Your Ref: 2026/0406

Our Ref: B/01593

18th June 2026

1 Kensington Avenue, Thurlstone - (BARNS) Formation of new detached residential property, including forming driveway and garden area

Site Plan (Scale 1:200)

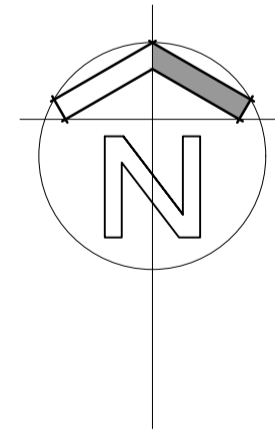
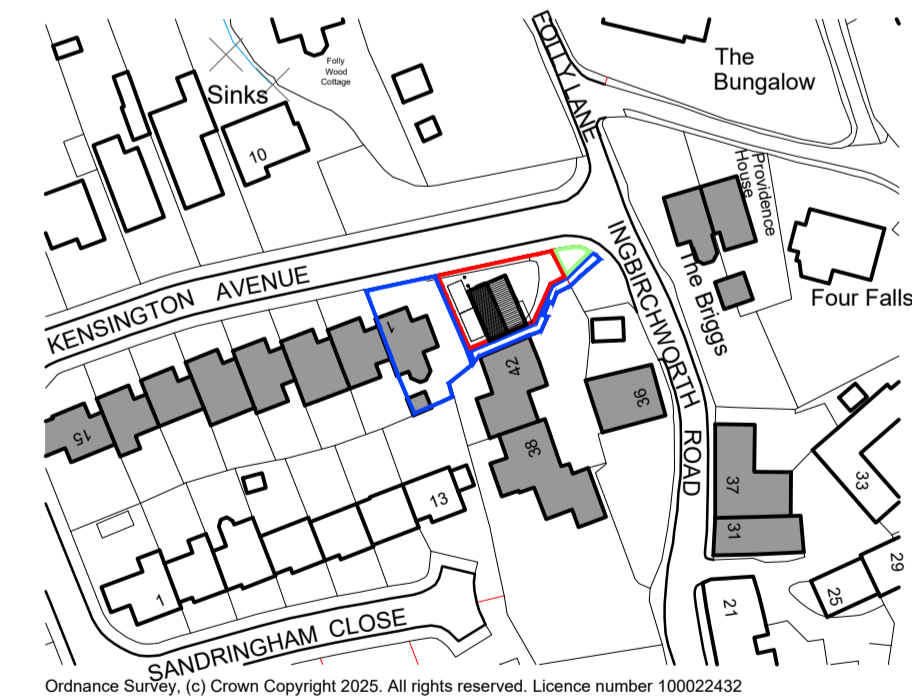
The developer is proposing to discharge surface water to SUDS, though the eventual outfall is unclear. Sustainable development requires appropriate surface water disposal.

Yorkshire Water promote the surface water disposal hierarchy, and the developer must provide evidence to demonstrate that surface water disposal via infiltration or watercourse are not reasonably practical before considering disposal to public sewer.

The developer and LPA are strongly advised to seek comments on surface water disposal from other drainage bodies as further restrictions may be imposed. There is a private surface water sewer network, approximately 3 metres off the western site boundary, that connects to culverted watercourse to the south – this should be fully explored as a means of surface water disposal.

As the proposal site is currently undeveloped, no positive surface water is known to have previously discharged to the public sewer network. Surface water discharge to the existing public sewer network must only be as a last resort and the developer is required to eliminate other means of surface water disposal.

As a last resort, and upon receipt of satisfactory evidence to confirm the reasons for rejection of other methods of surface water disposal, curtilage surface water may discharge to public sewer at a restricted rate not to exceed 3.5 litres per second..

There shall be no piped discharge of surface water from the development prior to the completion of surface water drainage works, details of which will have been submitted to and approved by the Local Planning Authority. If discharge to public sewer is proposed, the information shall include, but not be exclusive to:

- i) evidence that other means of surface water drainage have been properly considered and why they have been discounted; and**
- ii) the means of discharging to the public sewer network at a rate not to exceed 3.5 litres per second.**
